Portishead Branch Line (MetroWest Phase 1)

Planning Inspectorate Reference: TR040011

9.3.11 ExA.SoCG-ASP.D1.V1 – Statement of Common Ground

- (1) North Somerset District Council; and
- (2) Avon and Somerset Constabulary

Drawing
PORTISHEAD STATION CAR PARK
LAYOUT, LANDSCAPING AND NEW
BOULEVARD AND ACCESS PLAN
SHEET 2 OF 3

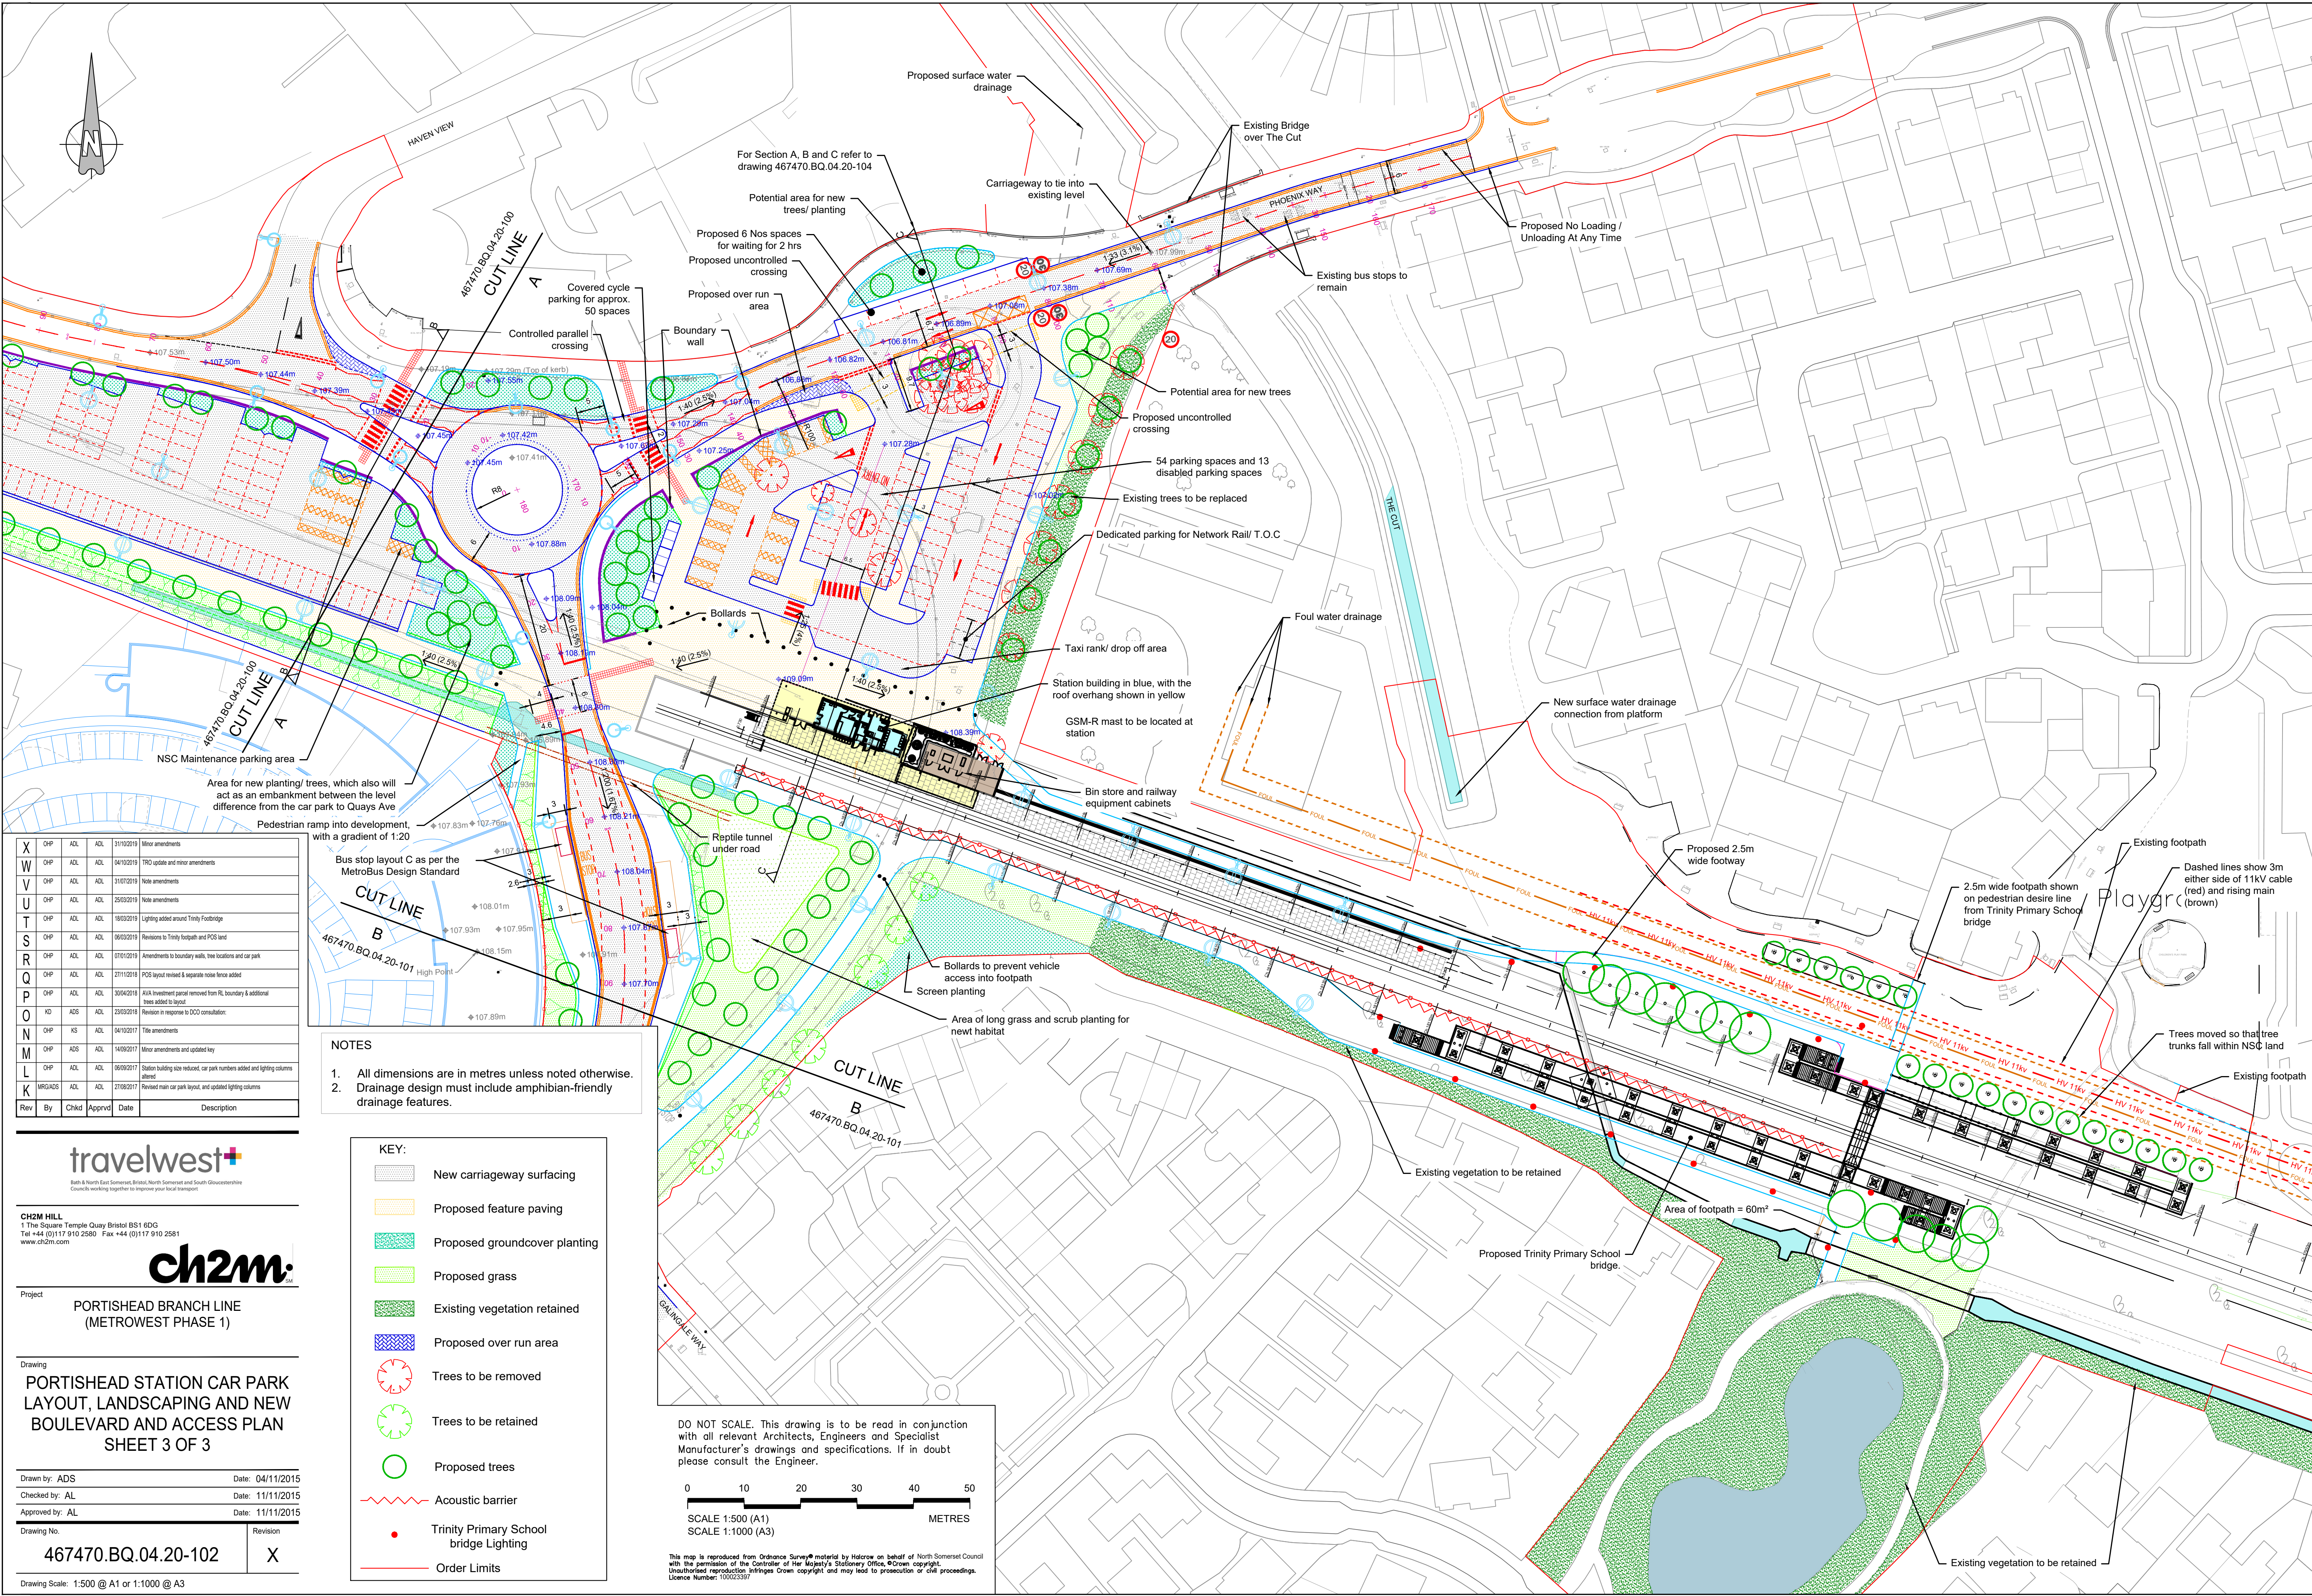
Topic	Avon and Somerset Constabulary position	Applicant position	Status
Portishead and Pill station car parks	<p>Stated concerns regarding:</p> <ul style="list-style-type: none"> • design allows vehicle and pedestrian access day and night; • height restriction or barriers on the entrance to prevent misuse of the car park when the station is closed. 	<p>The car parks will not be used exclusively by station users and will have 24-hour operation.</p> <p>A height restriction barrier is proposed for both Portishead and Pill. The details of which will be included in the detailed designs after the DCO Application submission.</p>	Agreed
Portishead Station security	Requested use of bollards/street furniture to prevent vehicle access onto large forecourt and pedestrian areas at Portishead Station.	These have been incorporated in the design in line with guidelines, as shown on the station designs. At Portishead Station the bollards separate the car park from the station building, and prevent access to the boulevard and pedestrian areas.	Agreed

Portishead Station anti-social behaviour	Requested that the design and locations of seating at Portishead station should be carefully considered so as not to create a climbing aid or encourage inappropriate loitering or gathering that could intimidate other users of the site.	These concerns have been taken into account when considering seating locations at the station.	Agreed
Reduce risk of bike theft	Requested that cycle parking provision be of the latest security standards and located to	The location and type of stand provision has been carefully considered, balancing all	Agreed

2.42 - Pill Station Car Park and PSP Layout, Landscaping Lighting and Access Plan

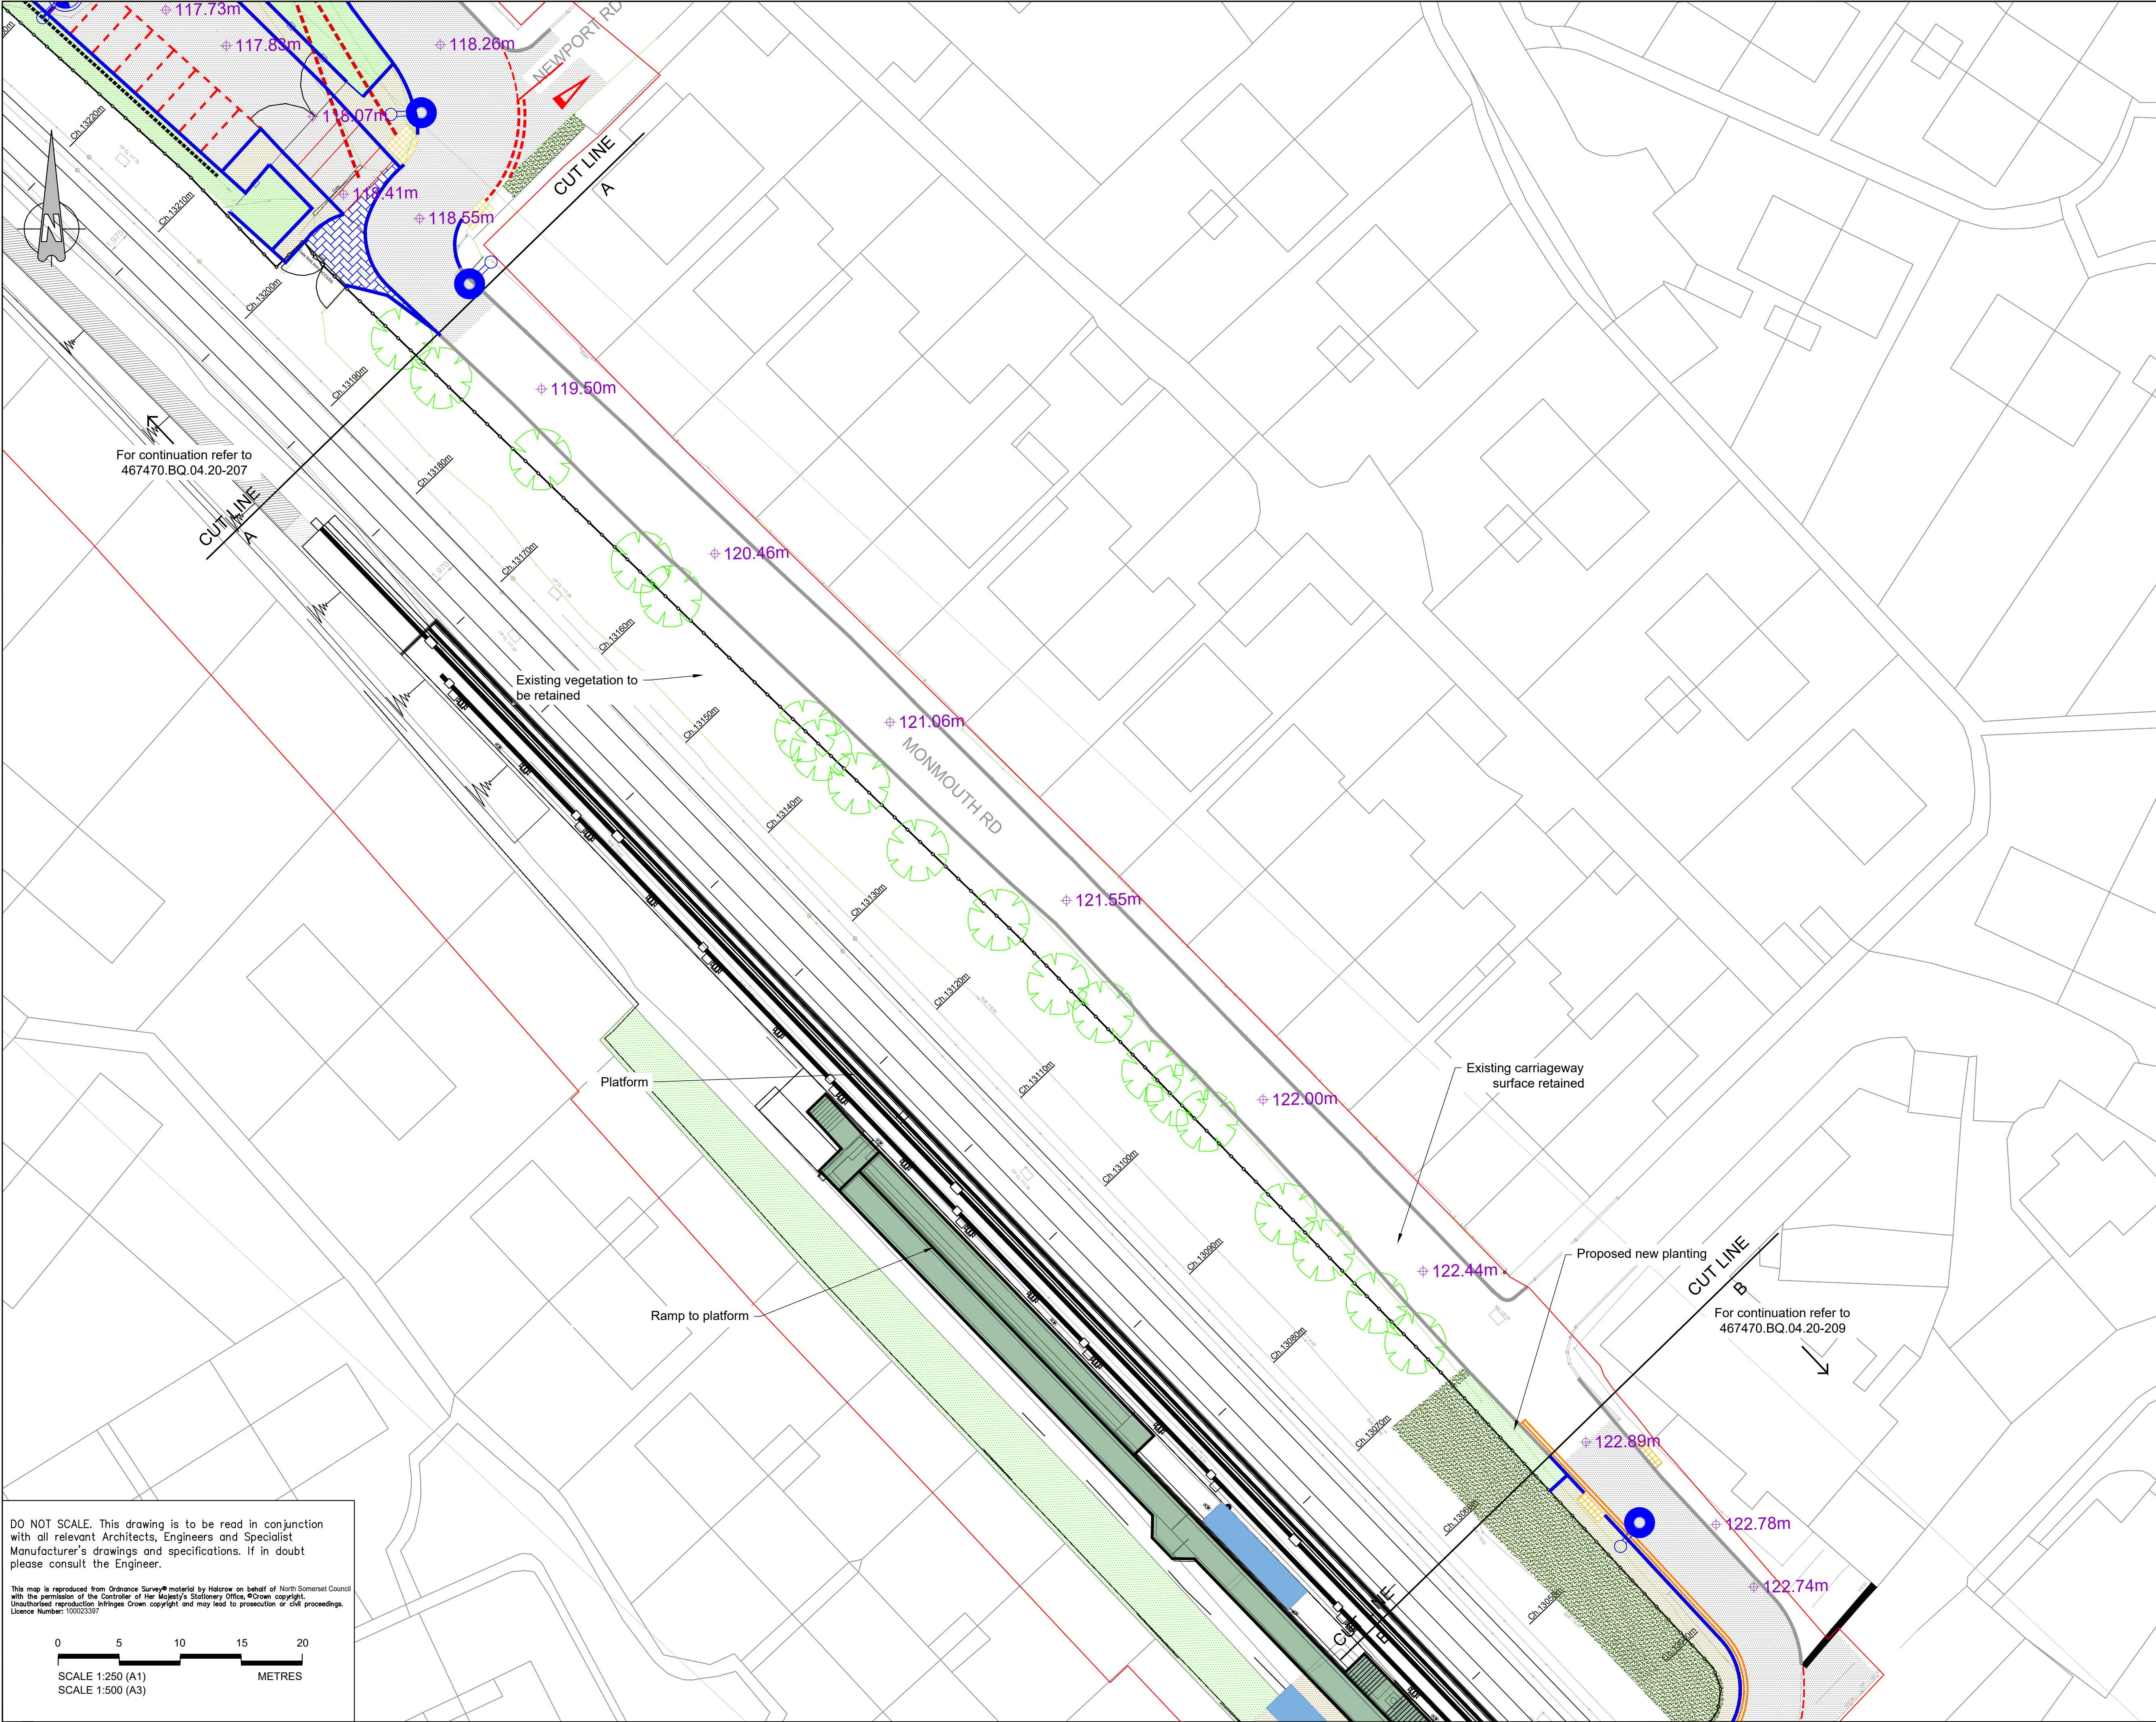
Pill Station car park security	<p>Stated that [Pill station car park] appears to show a gated entrance. Will this be locked at night to prevent nuisance vehicles using this facility at night? How will this facility operate? No height restriction barrier is shown to prevent unauthorised large vehicles accessing it.</p>	<p>The car parks will not be used exclusively by station users and will have 24-hour operation and will therefore not be gated.</p> <p>A height restriction barrier has been included at both Portishead and Pill and will be included in the detailed designs after the DCO application submission.</p>	Agreed
